Please ask for: Mrs D Johnson
Email: daun.johnson@arun.gov.uk
Telephone: 01903 737762
Our Ref: AL/52/20/PL
Your Ref:
Date: 10th July 2020

Application for Planning Permission

Development: Erection of a block of 3 stables.
Location: North Cottage Arundel Road Aldingbourne PO18 0JX

SIDE ELEVATION

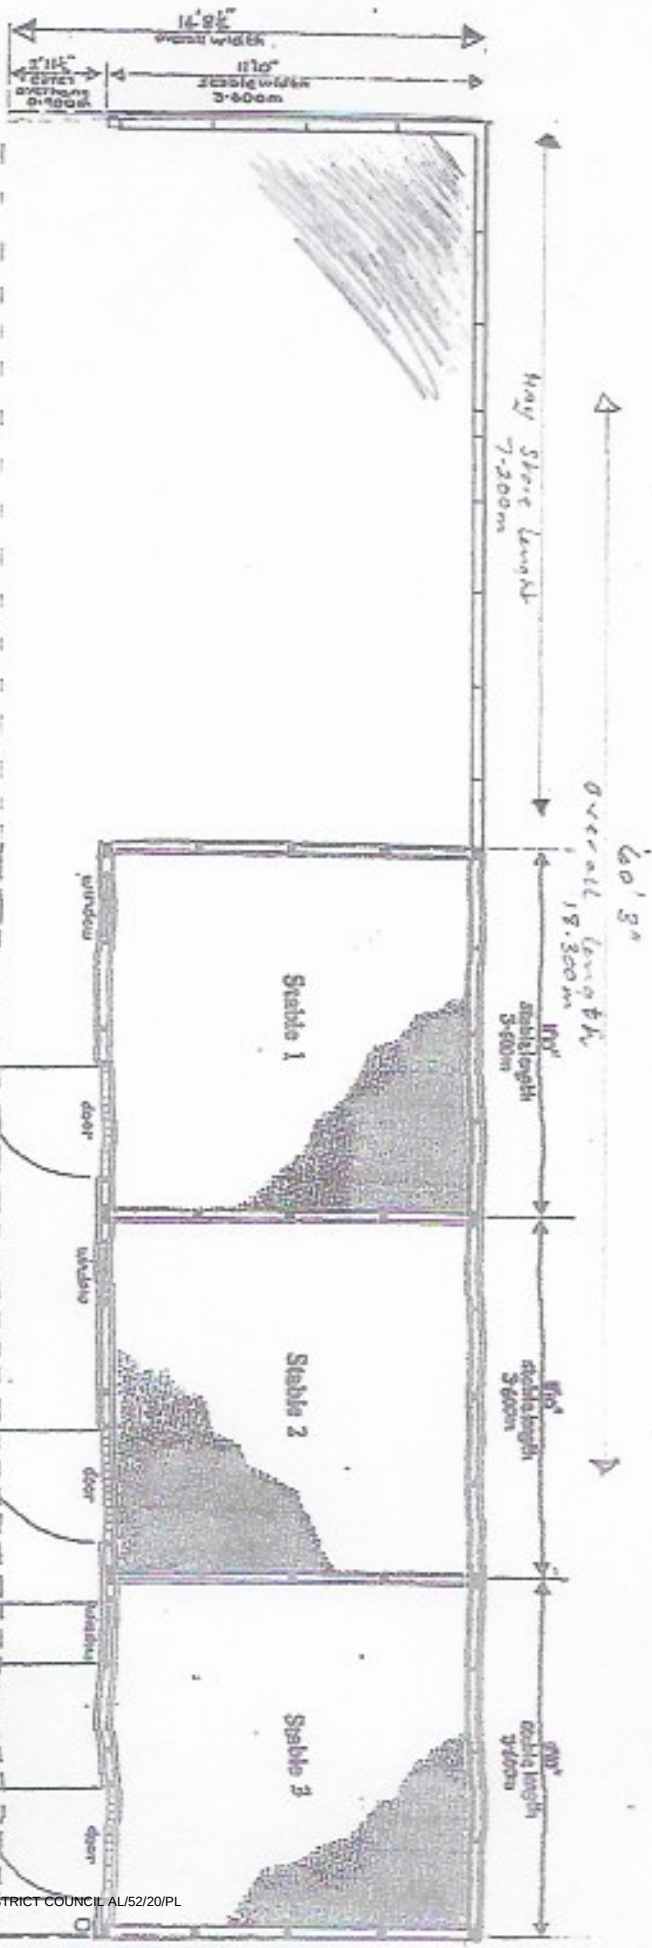
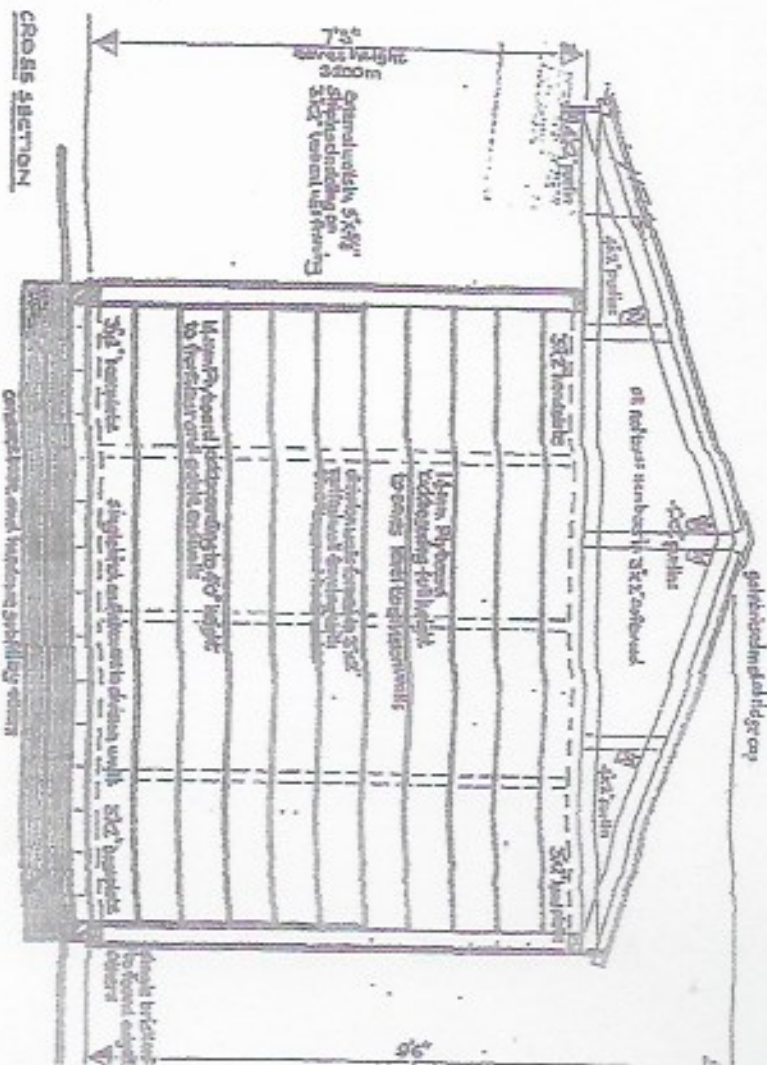
Please provide the other side elevation to the stables or label the existing side elevation as elevations.
